DOC18/621331-1
DA 305-11-01 MOD 7

Liddell Coal Mine (DA 305-11-01) Modification 7

OEH's recommendations

OEH's detailed comments

APPENDIX 3 CONCEPTUAL FINAL LANDFORM

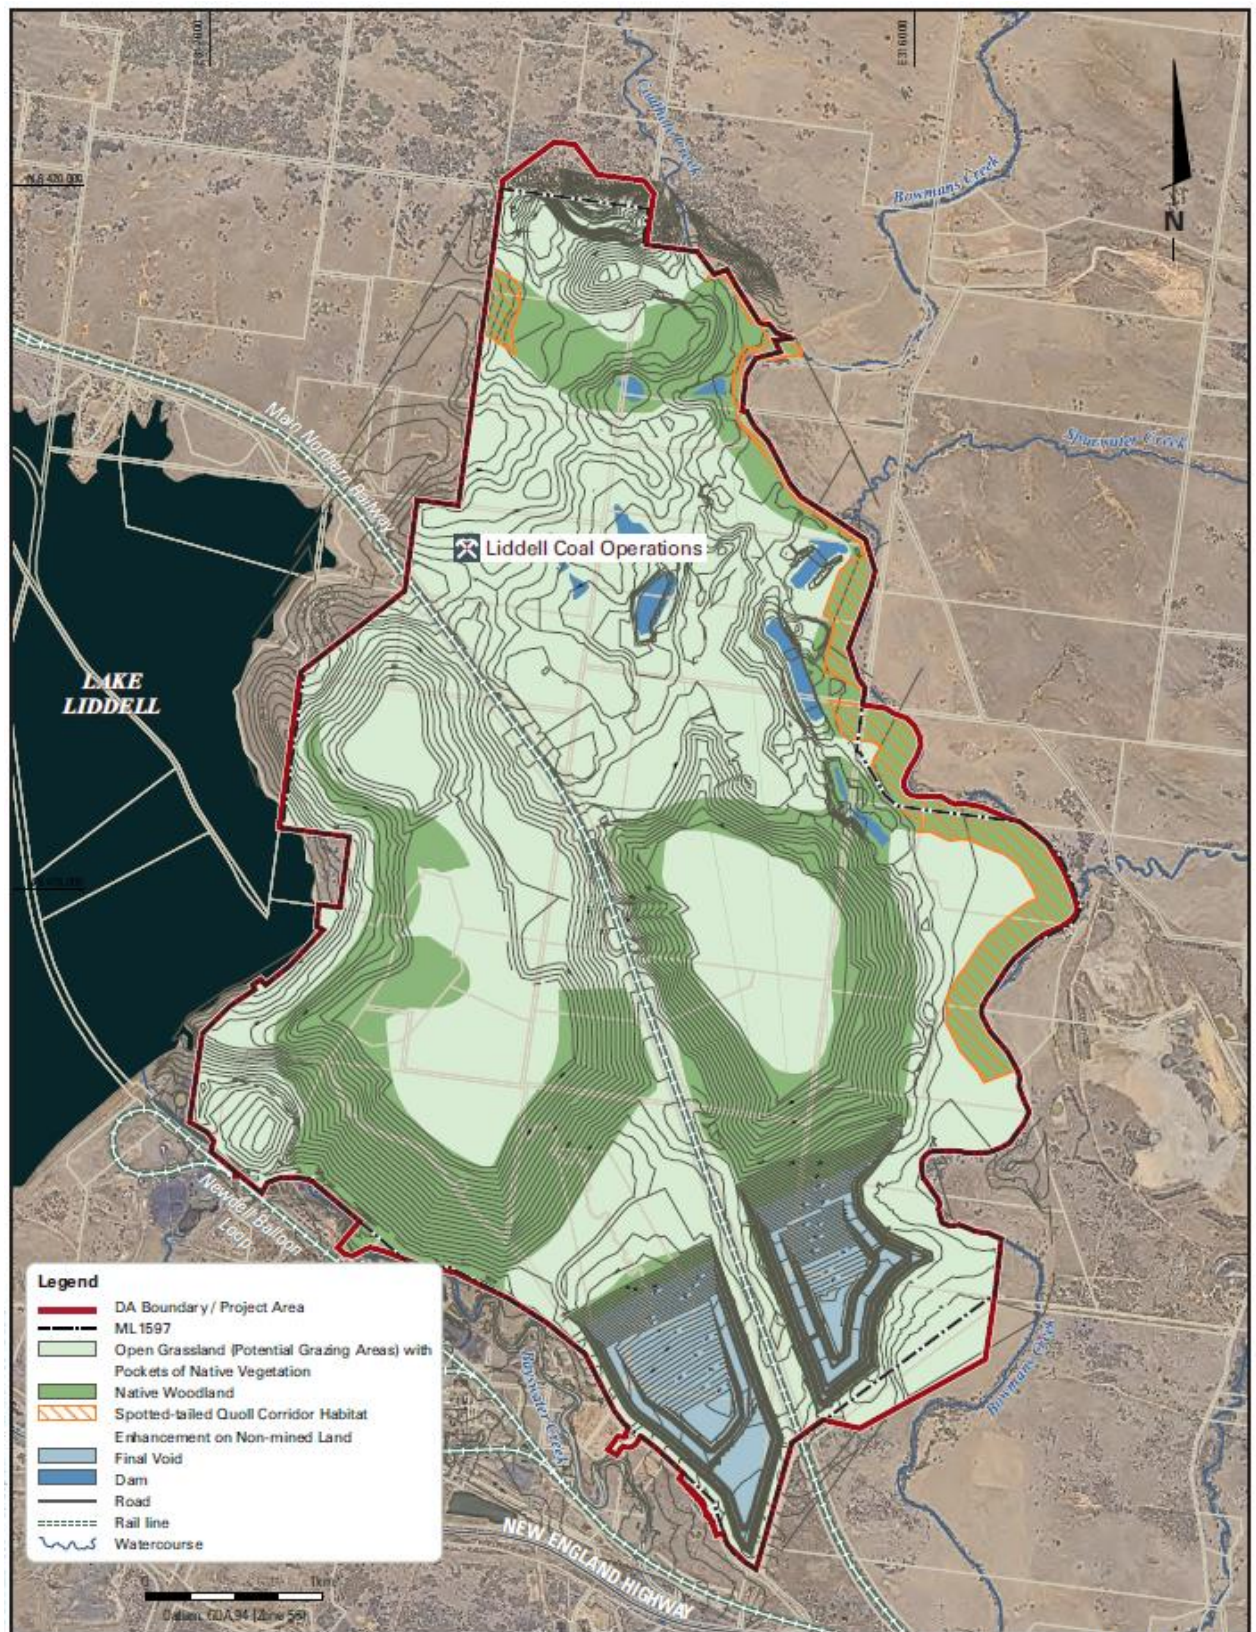
Rehabilitation objectives for the mine site are defined in consent Condition 37 of Schedule 3 and shown schematically in *Appendix 3 Conceptual Final Landform* of DA 305-11-01. The proposed changes of this condition relate to the achievement of specified revegetation areas. The Conceptual Final Landform map in *Appendix 3* of DA 305-11-01 indicates a number of dams

along the eastern side of the site. Any changes to the final landform of the mine site need to ensure that any properties not owned by the proponent are not adversely impacted by flood waters as a result of the changes in landform, for the full range of flood events, up to and including the Probable Maximum Flood (PMF).

OEH recommends that any changes to the Conceptual Final Landform must not adversely affect flood characteristics on privately owned properties, for the full range of flood events, up to and including the Probable Maximum Flood (PMF).
